Subject: 372-374 Mann Street and 35-37 Dwyer Street, North Gosford – Response to Submissions

Stockbridge Properties Pty Ltd (the applicant) lodged a State Significant Development Application (SSDA) for the mixed-use development at 35-37 Dwyer Street and 372- 374 Mann Street, North Gosford (SSD-69773460). The proposal includes construction of a mixed-use development comprising three buildings ranging in height from seven storeys to 22 storeys containing residential apartments, commercial/retail floor area and basement car parking.

This letter has been prepared to respond to all traffic and transport related comments and should be read in conjunction with Transport Assessment prepared by Ason Group, dated 30 May 2025¹ which supported the SSDA.

1 BASEMENT 1 PLAN
SCALE: 1 : 250

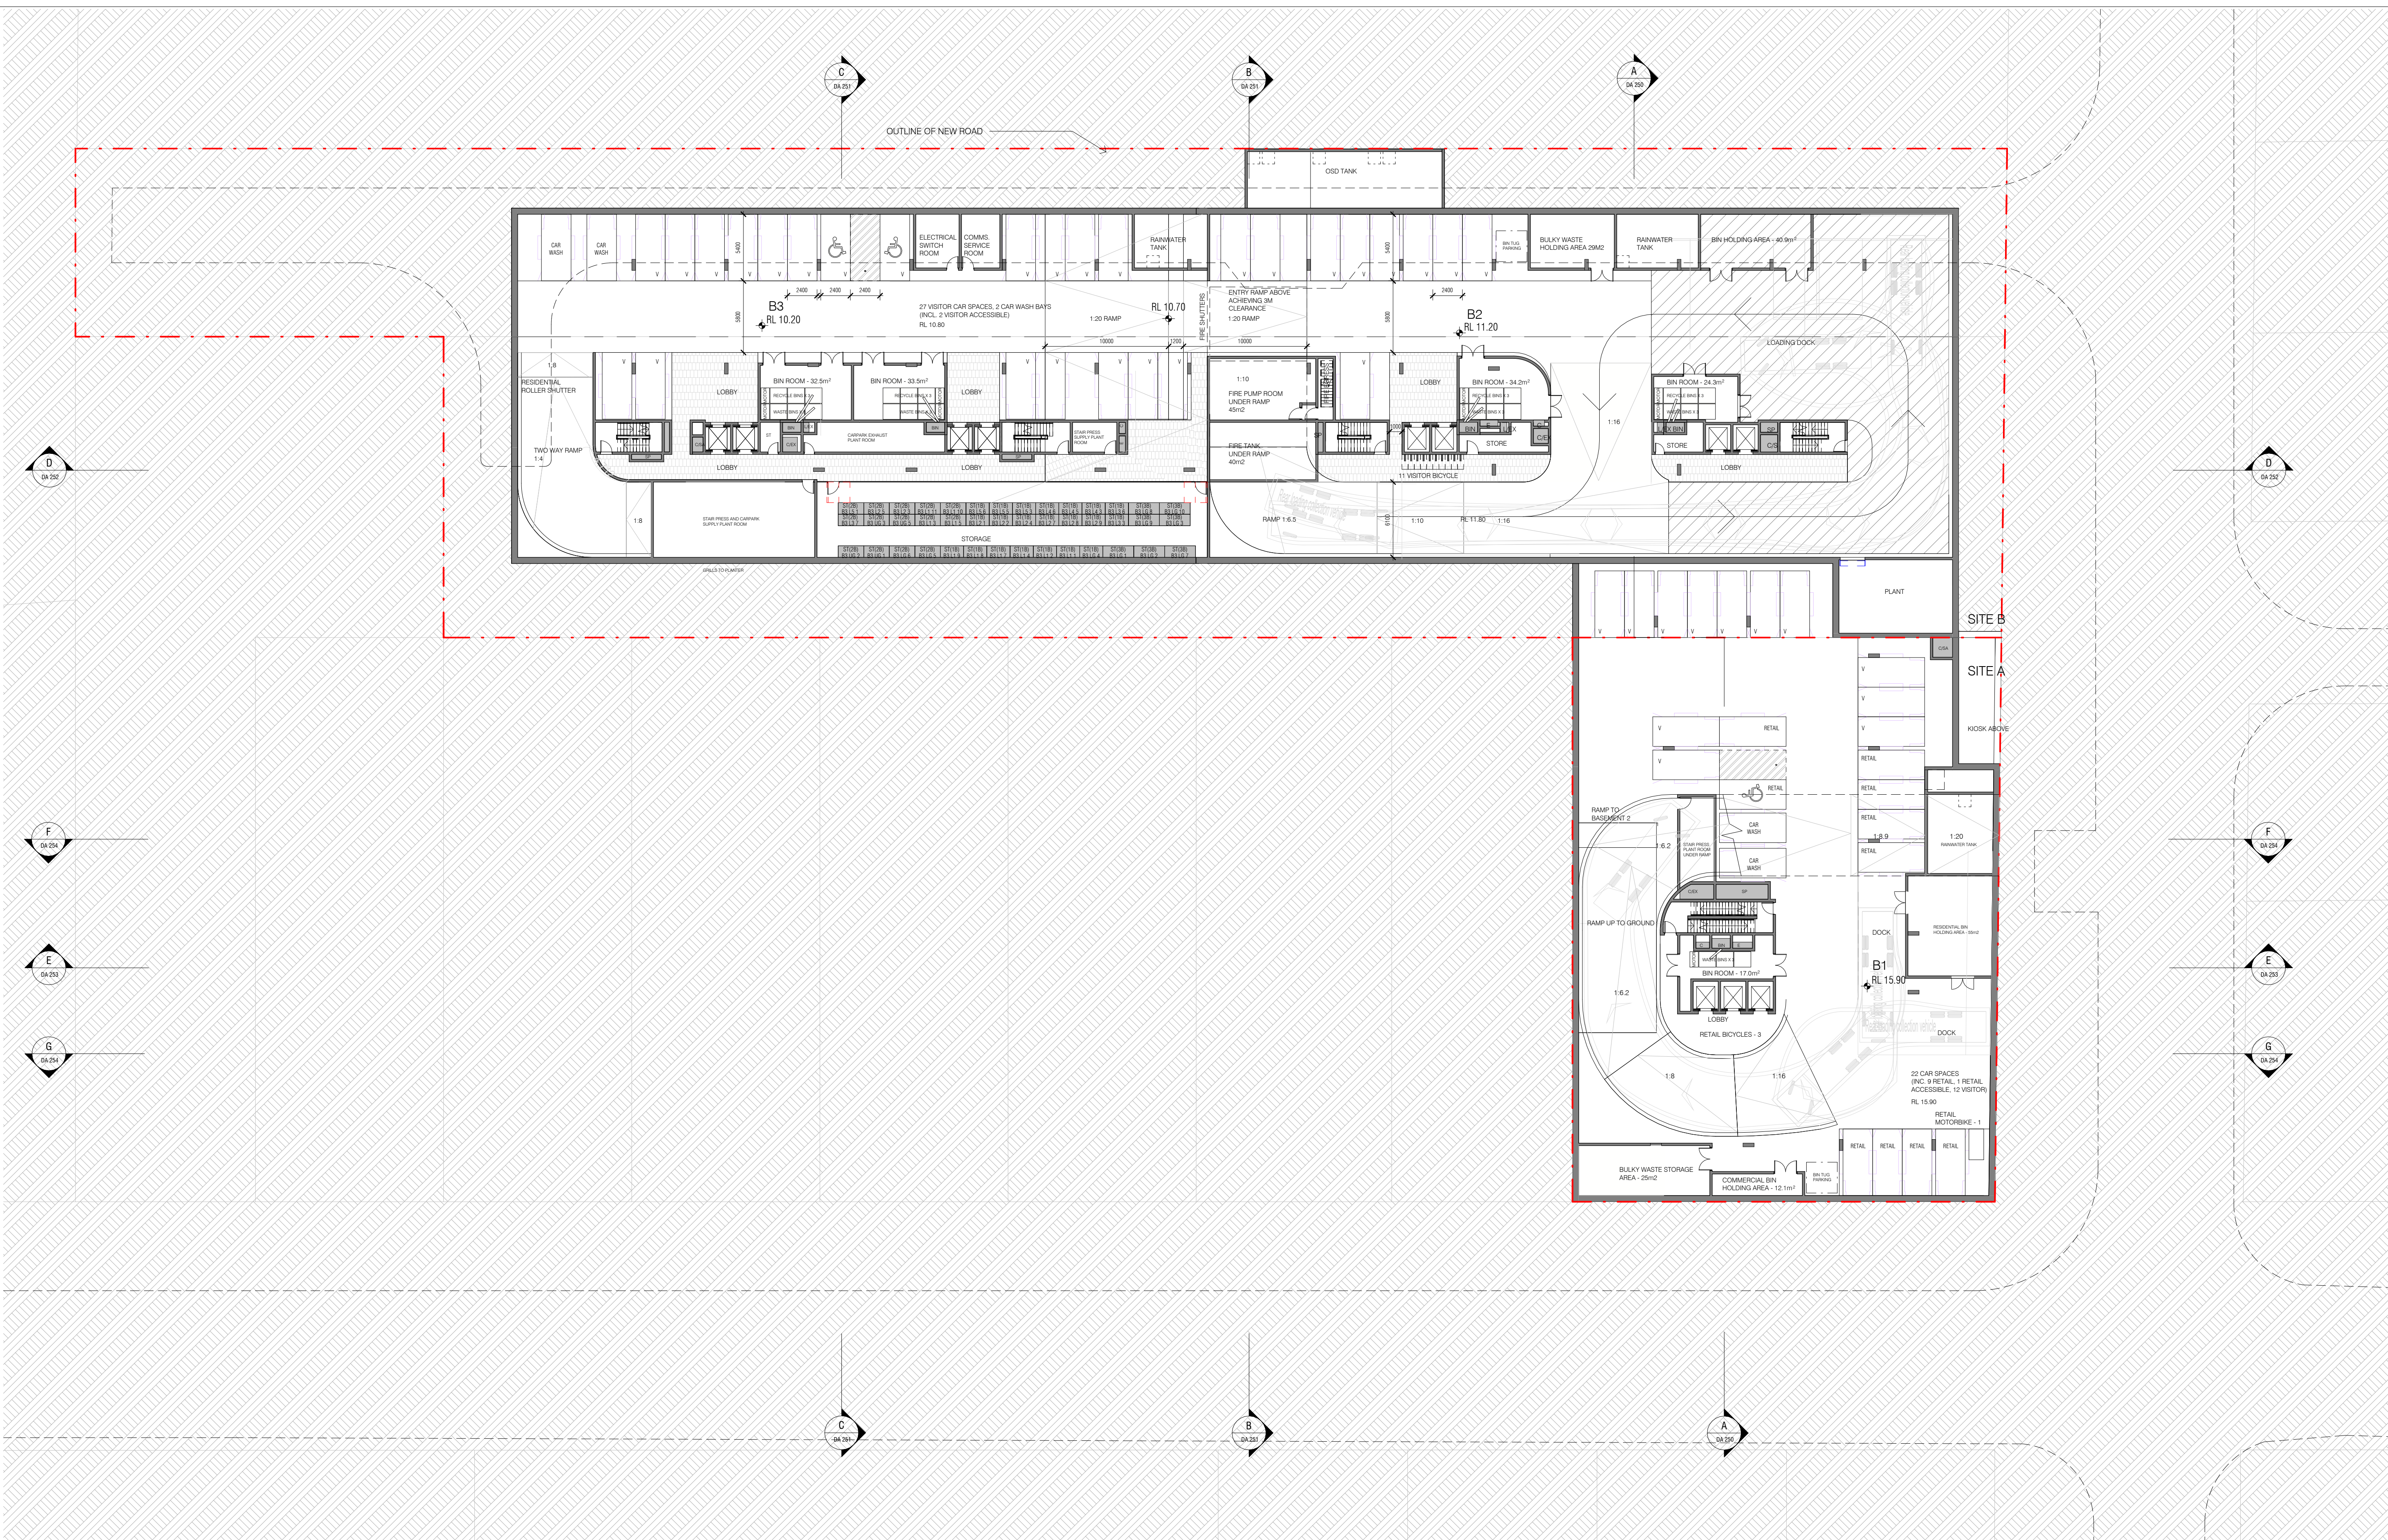
Council Comment – Engineering: *The grades on the access ramp from the Dwyer Street level to Basement 1 level (RL 15.90) for Building B1 (Site A) are indicated at 1:6 (i.e. 16.7%). These grades exceed the maximum 1:6.5 (i.e. 15.4%) permitted in AS2890.2018 for access for commercial vehicles (including the proposed service vehicles) proposed to utilise this ramp. The consent authority will need to ensure that the proposal is amended to comply with the maximum grade of 1:6.5 (1 in 6.5) permitted under AS2890.2:2004.*

- confirming that the proposed 1:6.5 ramp grade meets AS2890.1 and other relevant standards. Provide detailed ramp design drawings and transition lengths.

This comment is acknowledged and the ramp design has been amended to resolve these non-compliances, where practical. The ramp length has been extended from approximately 49.3-metre-long ramp (measured along the inside curve) in the submitted SSDA to approximately 50-51 metres. This extension reduces the ramp gradient and brings the design consistent with the requirements of AS2890.2:2018.

While minor non-compliances remain with respect ramp grades and transition lengths stipulated in AS2890.2:2018, it is supported based on the following:

- The ramp has been extended to the maximum extent possible within the available site area while considering the site boundaries, demonstrating efforts to minimise any such minor non-compliance.

- The maximum allowable roadway/ ramp grades are detailed in Table 3.2 of AS2890.2:2018, however, Clause 3.3.3.3 of AS2890.2:2018 states “Maximum grades in Table 3.2 are determined from the ability of a loaded design vehicle to commence forward movement on a specified grade. Steeper grades may be suitable for site/ task specific operators, for example, if vehicles are unlikely to stop on steeper grades”. The proposed ramp includes a maximum grade of 1:6.2 and designed to minimise deviations to the gradients stipulated in Table 3.2 of AS2890.2:2018.

- During waste collection, the ramp would provide one-way flow for waste vehicles. Traffic management measures will be necessary during the infrequent times when waste vehicles (and other heavy vehicles) enter and exit the basement loading areas. This would include a standard stop/go signal system, with laser detectors set at appropriate height to ensure cars are not captured. Therefore, the waste vehicle is expected to travel along the centre of the ramp when traveling to/ from the loading dock. Since gradient measurements taken along the inside curve represent the steepest portion of the ramp, the actual travel path traversed by waste vehicles and larger service vehicles would predominantly be on sections of the ramp that include more generous gradients (of at least 1:6.5) – and hence fully compliant with AS2890.2:2018.

- The proposed ramp gradients and transitions remain suitable for the type and frequency of commercial and residential vehicles anticipated to use the ramp (including waste vehicles) and would not compromise operational safety.

1 LOWER GROUND FLOOR PLAN
SCALE 1 : 250

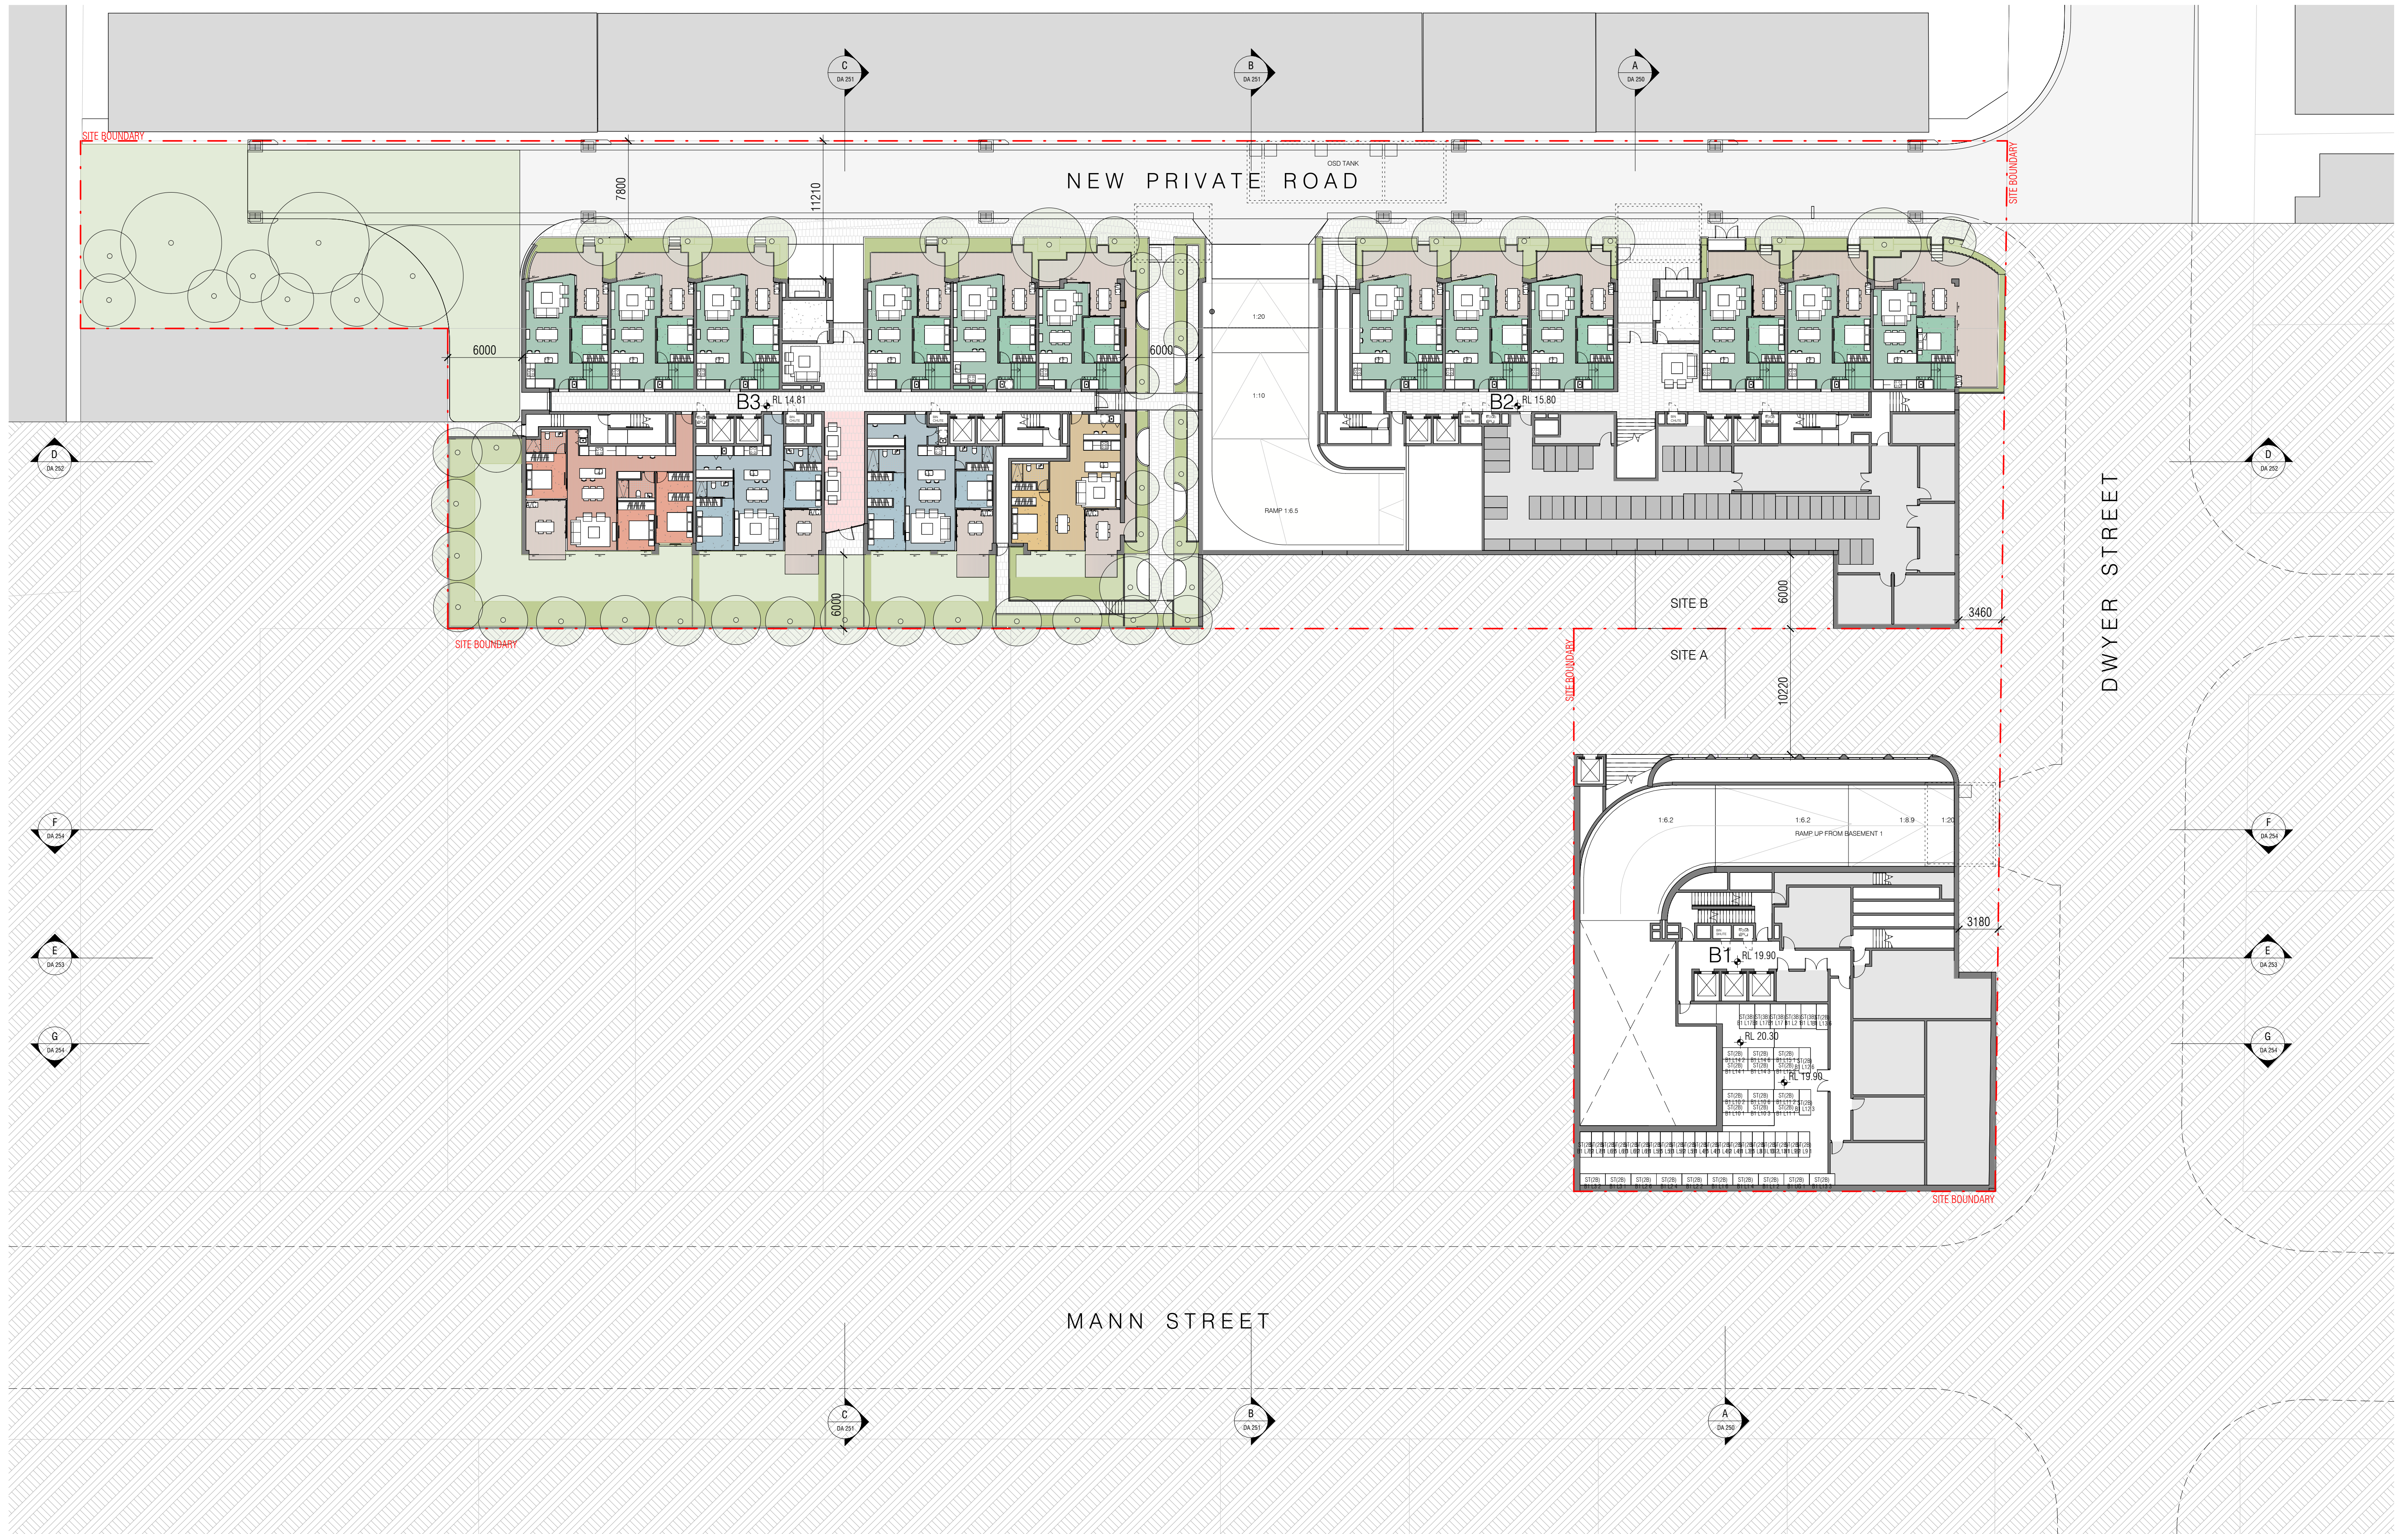
Council Comment – Traffic: No assessment has been made in relation to the location of the proposed driveway to building B1 opposite a T-intersection and its compliance with Australian Standard AS2890.1.

- demonstrating how the location of the proposed driveway to building B1 opposite a T -intersection achieves compliance with Australian Standard AS2890.1.

Figure 3.1 in AS2890.1:2004 requires driveways located opposite public roads be offset six metres from any adjacent or opposite road/ property boundary. When measured from the indicative edge of bitumen on Campbell Street, the proposed access driveway is offset about 12 metres, and the driveway splay is offset about 10.4 metres. When measured from the property boundary opposite, the dimensions are 7.0 and 5.5 metres respectively. In this regard, the driveway location is supported, especially having regard to the minor traffic volumes on both Dwyer Street and Campbell Street and given that all site generated traffic will turn left in and right out of the proposed access driveway.
